**Response to Department's Query:**

1 HAVILAH LA ELEVATION
SCALE 1 : 250

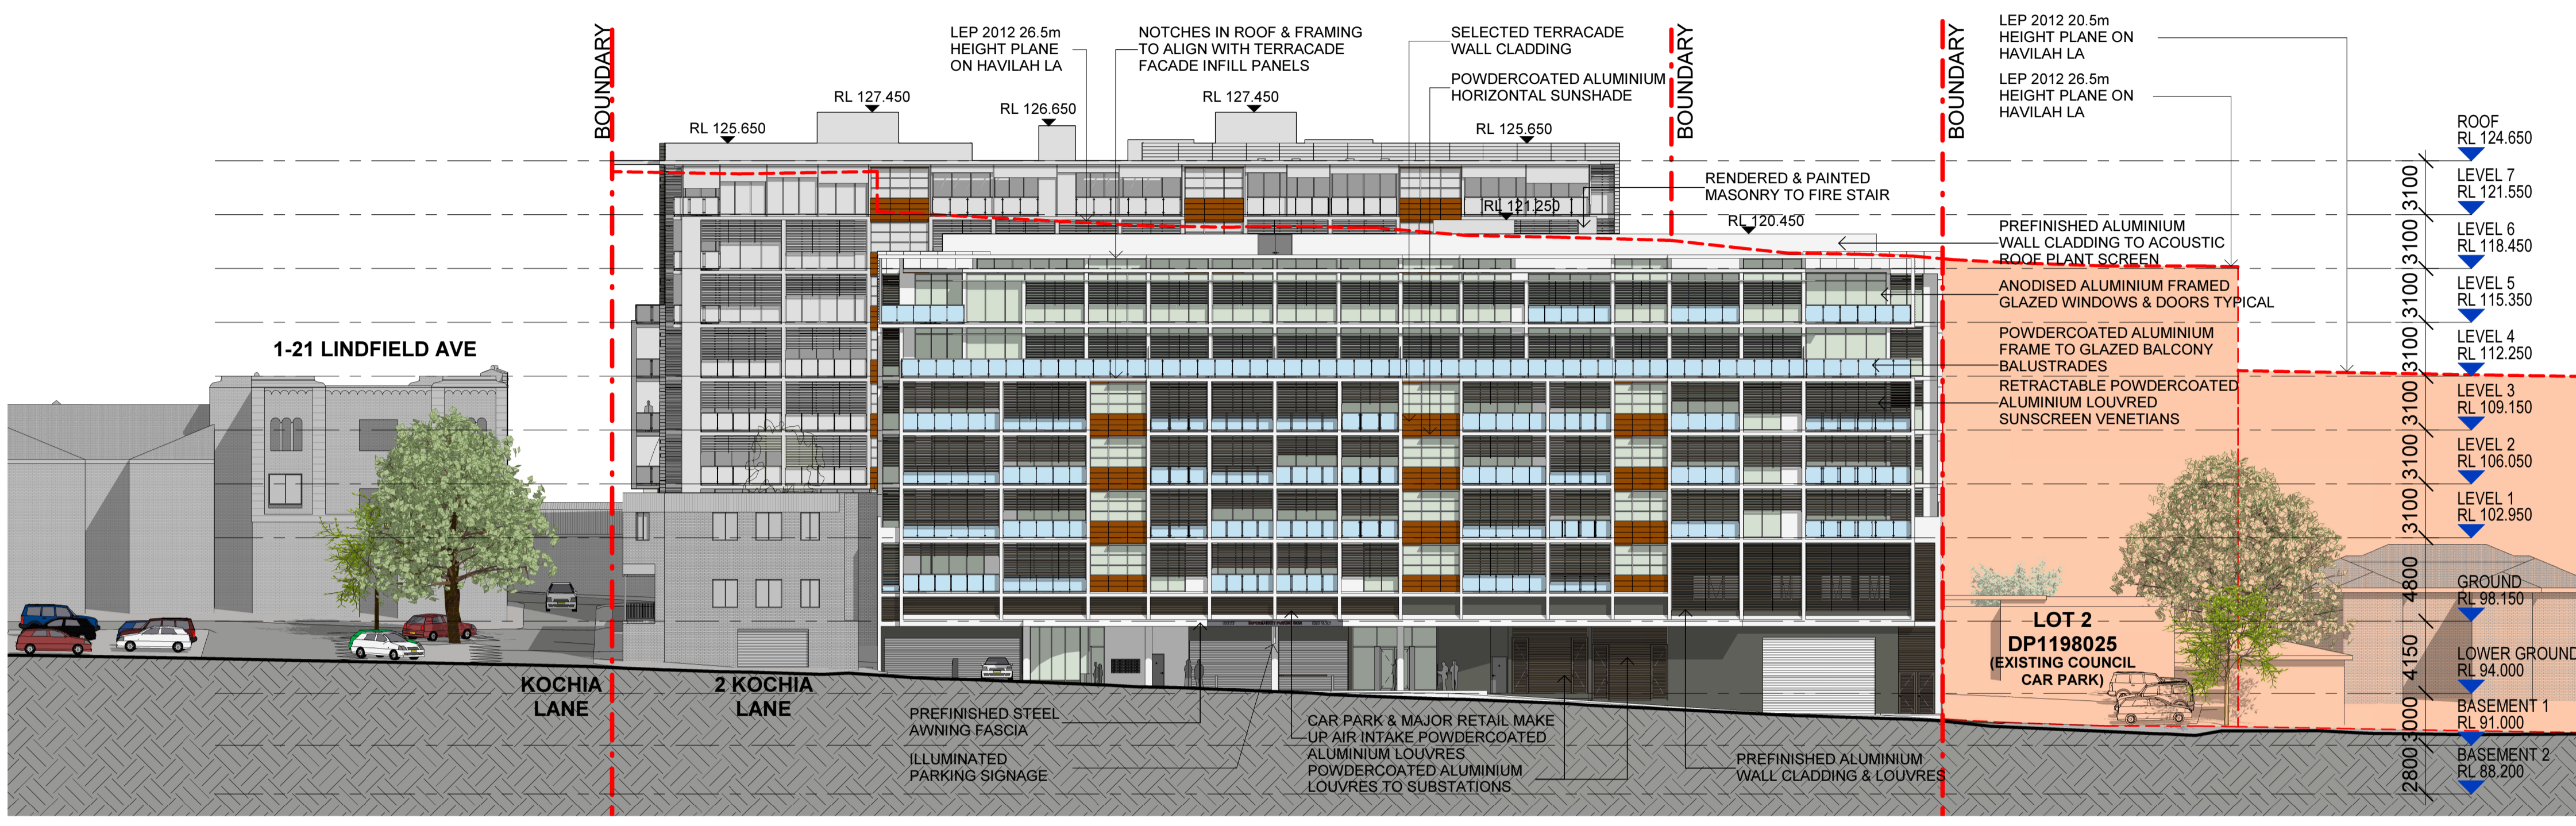
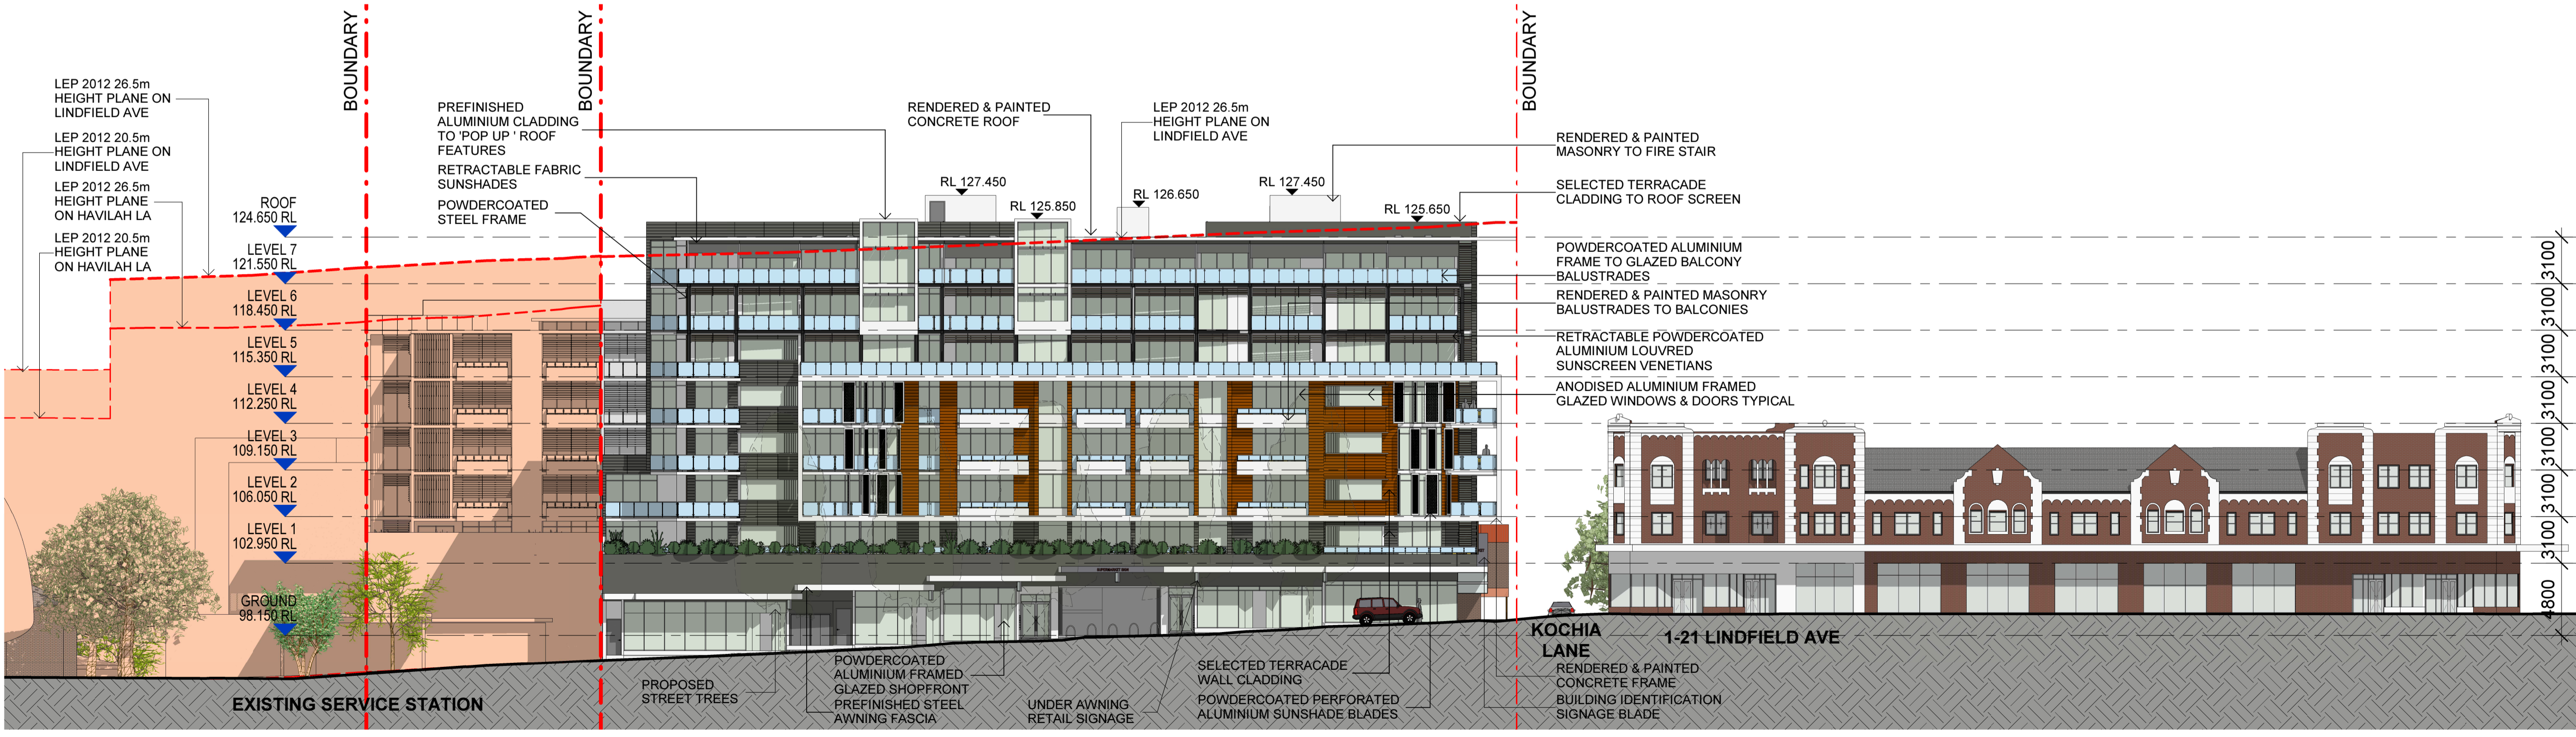
4. recommendations to ensure that suitable internal noise levels to apartments are achieved.
- This is particularly important if the Department is considering allowing the 5 apartments G01B - G05B at zero setback and limited height above Havilah Lane.

- If the Department is of a mind to allow apartments G01B - G05B, it should analyse the statements made by the applicant stating compliance with the Department's ADG (Apartment Design Guide) which in fact are incorrect. At a basic level, the conflict between the apartments and the basement access points below are unresolved and clearly inconsistent with the requirements of the ADG. Further, given the noise levels and proximity to the laneway of these apartments, the Department is asked to consider the actuality of utilising the openings for ventilation or private open spaces in addition to the limited standards of habitable rooms lit by snorkel windows in the poorest apartment at G05B, or no windows to the dining/habitable area within G03B; and no solar access (as required by ADG) to living rooms which are shadowed by façade setbacks (solar access to bedrooms does not make apartments compliant with ADG).
